MEMORANDUM

RE: LS Residence (Permit #1708-086), Mercer Island Corrections Notice 1, dated 1/17/18.

Drawing Number
S2.0

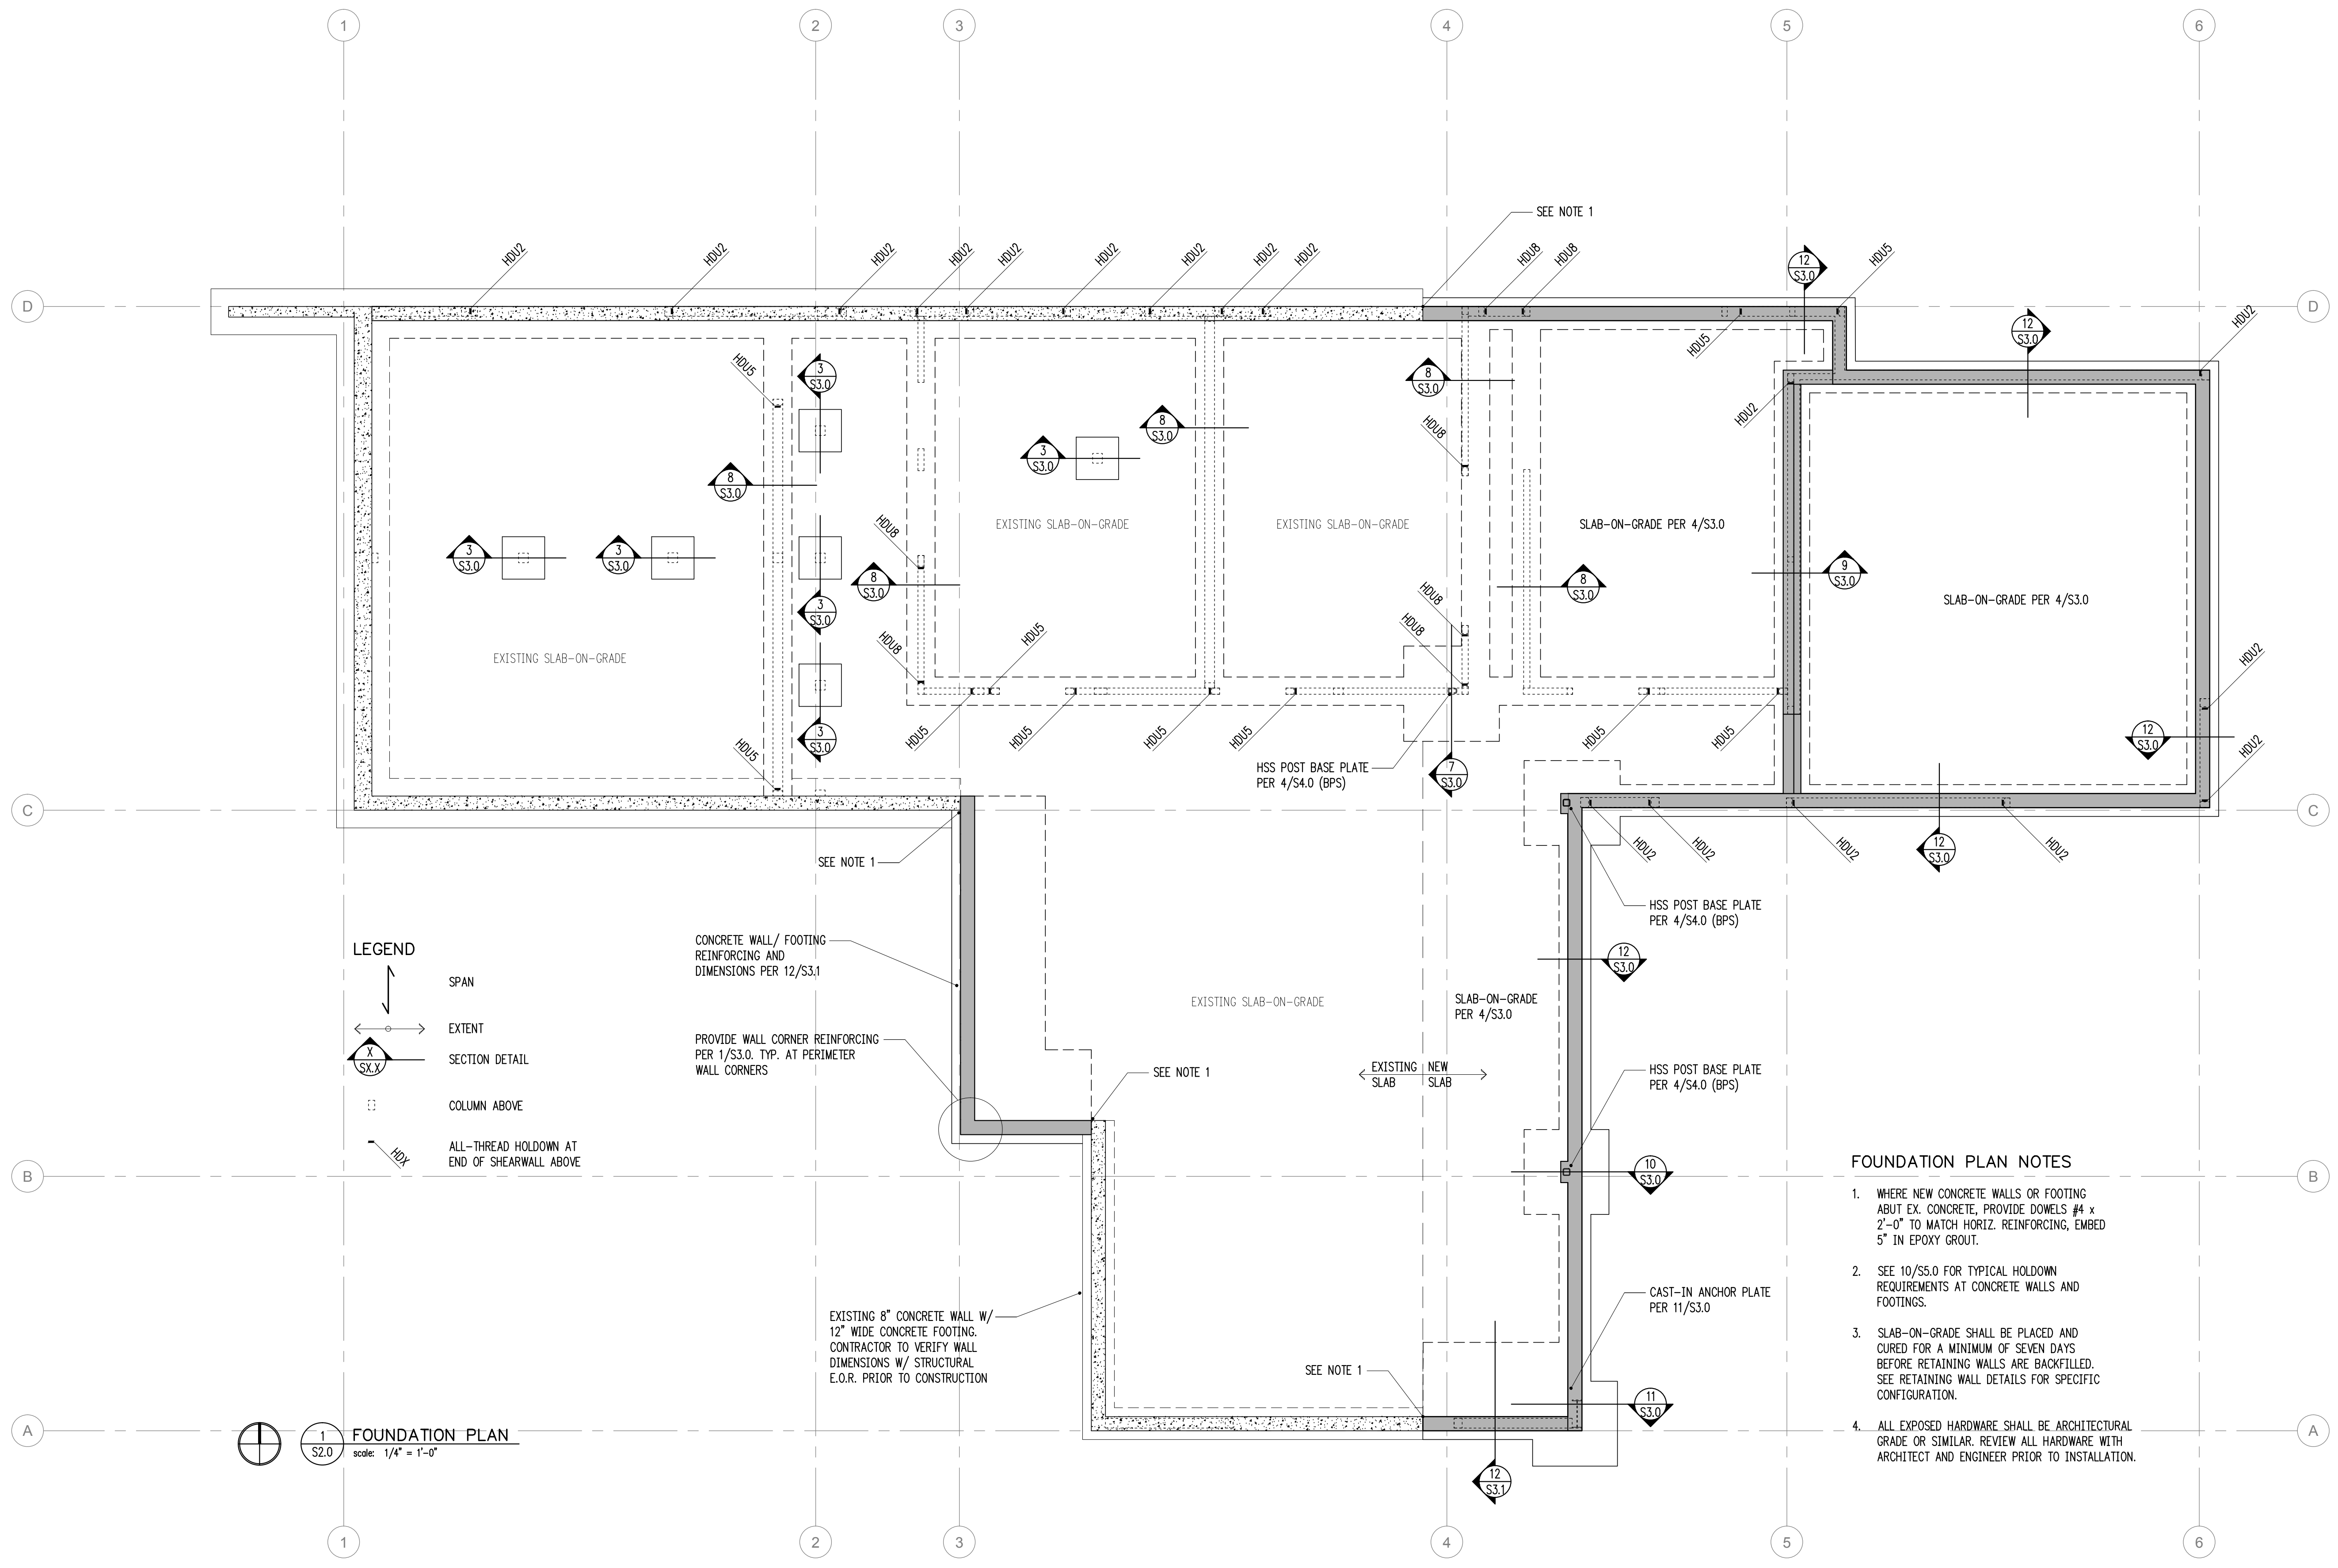
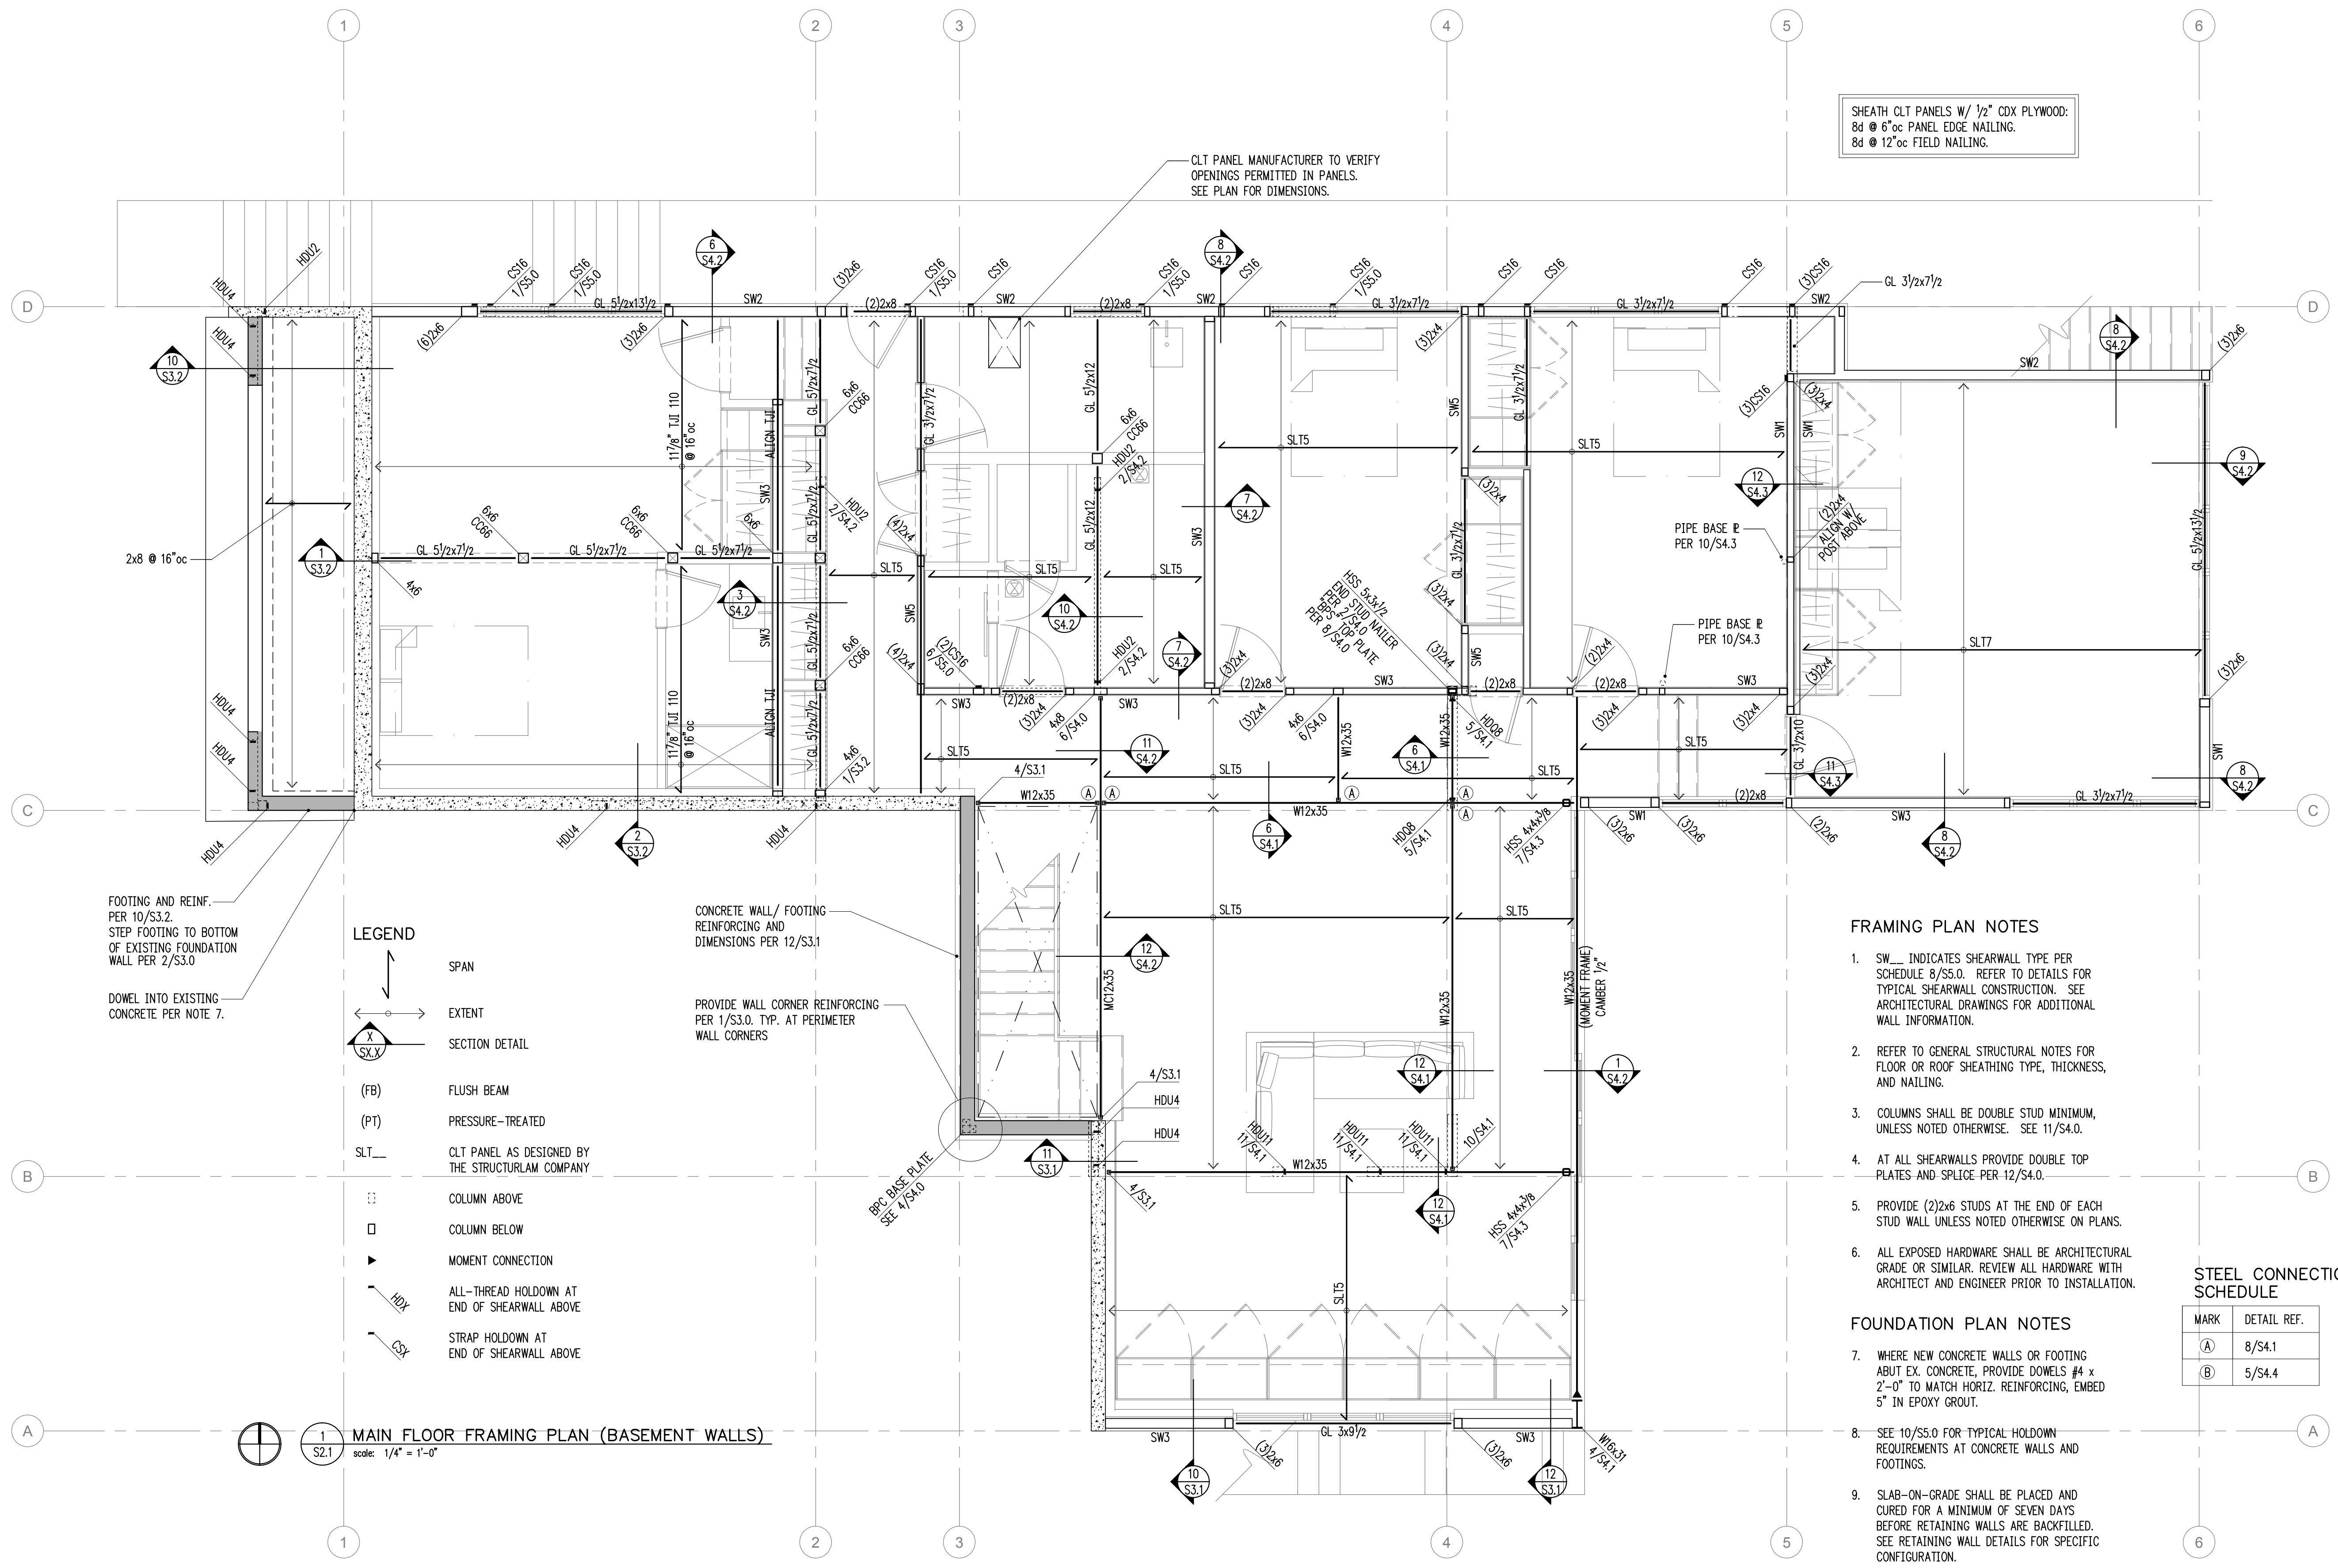
| S2.0 | 1) <i>Provide calculations for hold-down anchor table 10/S5.0. That detail appears to only apply at stem wall construction. Many of these anchors are installed in thickened slab. Designate on plan which anchors are post-installed in existing concrete and provide calculations, notes and details specific to that installation (10/S5.0 states that all are cast in place)</i> |

- 2) *Provide calculations for retaining wall shown in 12/S3.1*

- 3) *Coordinate with arch to provide footings for exterior stair (see A507)*

Note to cast-in or epoxy holdowns have been added next to each foundation holddown callout. Holddowns not called on plans have been removed from

schedule. HDU4 epoxy embedment in 10/S5.0 has been updated. Please see detail 12/S5.0 for notes how to cast anchors through stem into footing for increased capacity.

Detail 6/S3.0 has been added and referenced on plans for increased concrete depth for HDU8 anchors.

See Attachment A for holddown calculations. These values are designed for the maximum loads the holddown hardware can transmit to the anchors. Holddowns specified in shearwall calculations have been verified for a demand less than the allowed capacity of specified holddown.

See Attachment B for retaining wall calculation.

Strip footing has been added to the plan sheet as well as a new detail (5/S3.0) to show footing and wall detailing at exterior stair.
